November 14, 2011

Subject: **Revised Application for a Section 404 Individual Permit, Section 401 Water Quality Certification, and Neuse Riparian Buffer Authorization** for construction of the widening of NC 42 from US 70 (Clayton) to east of SR 1902 (Rocky Branch Rd) in Johnston County. Federal Aid Project No. STP-42(4). State Project No. 8.1312301. TIP No. R-3825A.

Reference: NCDOT application dated August 12, 2011

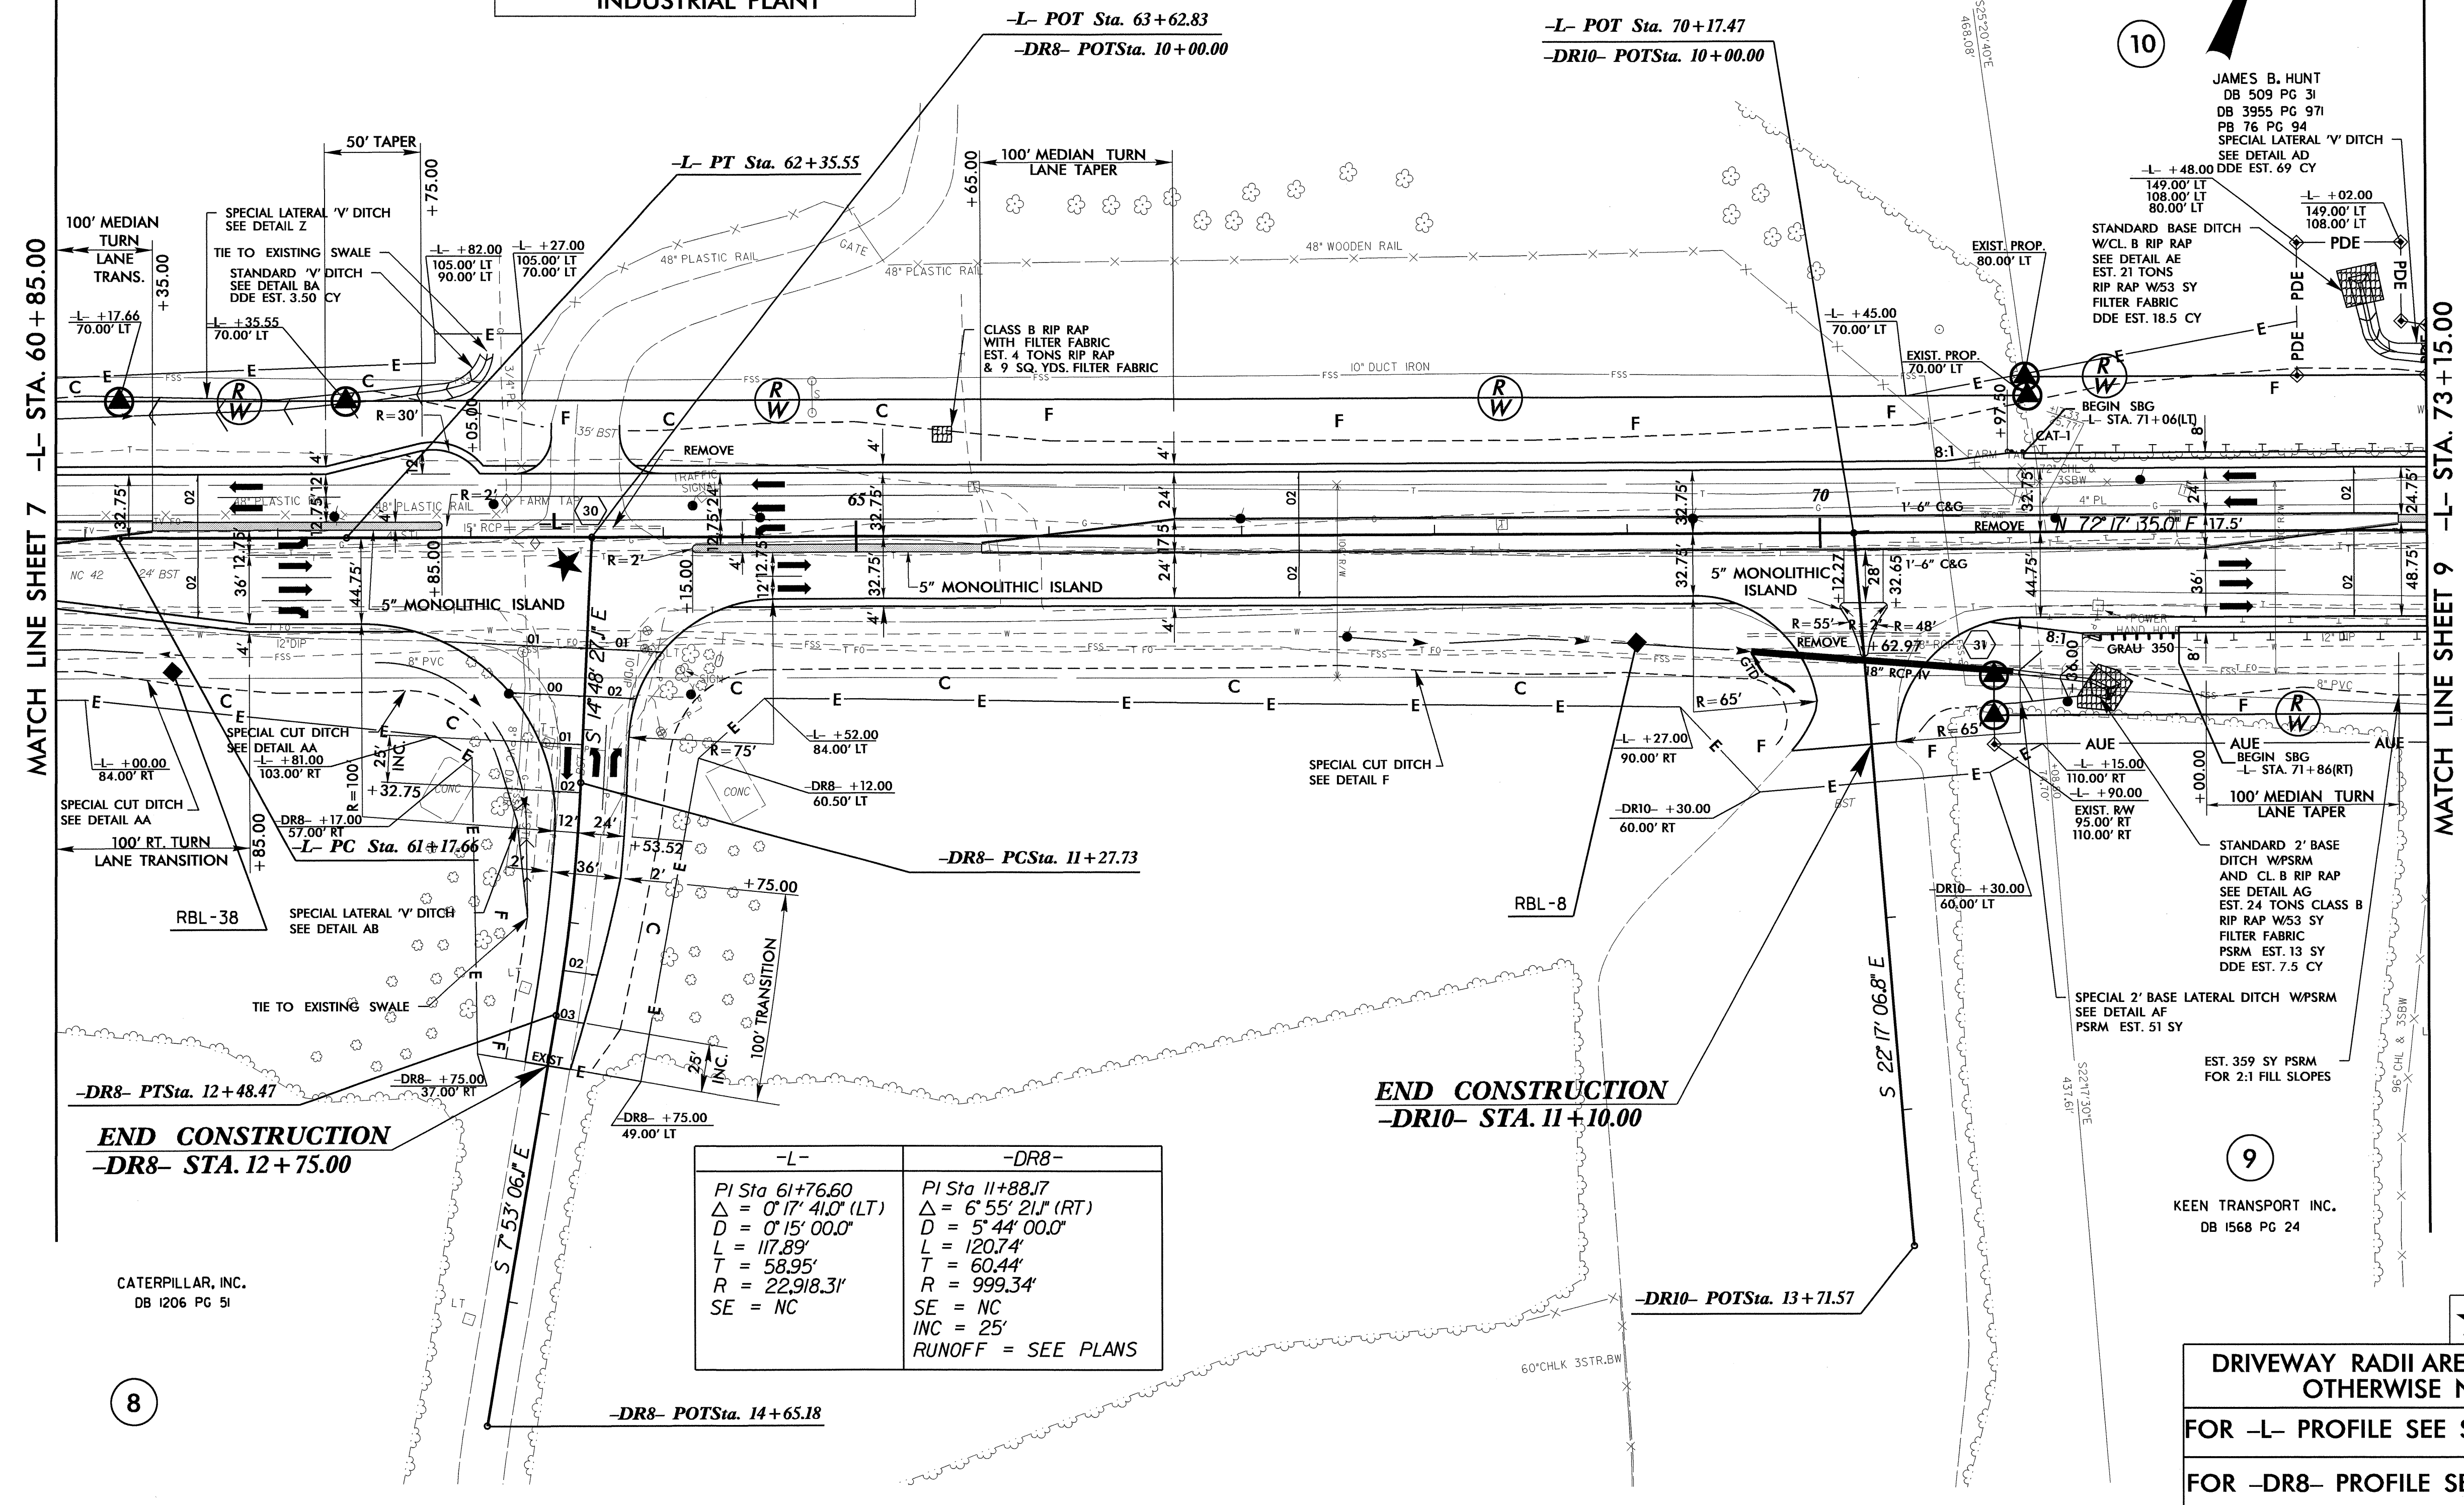
- (Sheet 7) -Revising Temporary Construction Easement to Permanent Drainage Easement around ditch on Parcel No. 8.
- (Sheet 8) -Revising Temporary Drainage Easement to Permanent Drainage Easement around ditch on Parcel No. 10.
-Modifying Temporary Construction Easement on Parcel No. 9.
- (Sheet 9) -Adding Permanent Drainage Easement around pipe outlet on Parcel No. 9.
-Removing a property line and eliminating Parcel No. 15.
-Revising Parcel No. 10 to Parcel No. 10A from station 76+78.74 to station 80+14.22.
-Modifying Temporary Construction Easement on Parcel No. 10A.
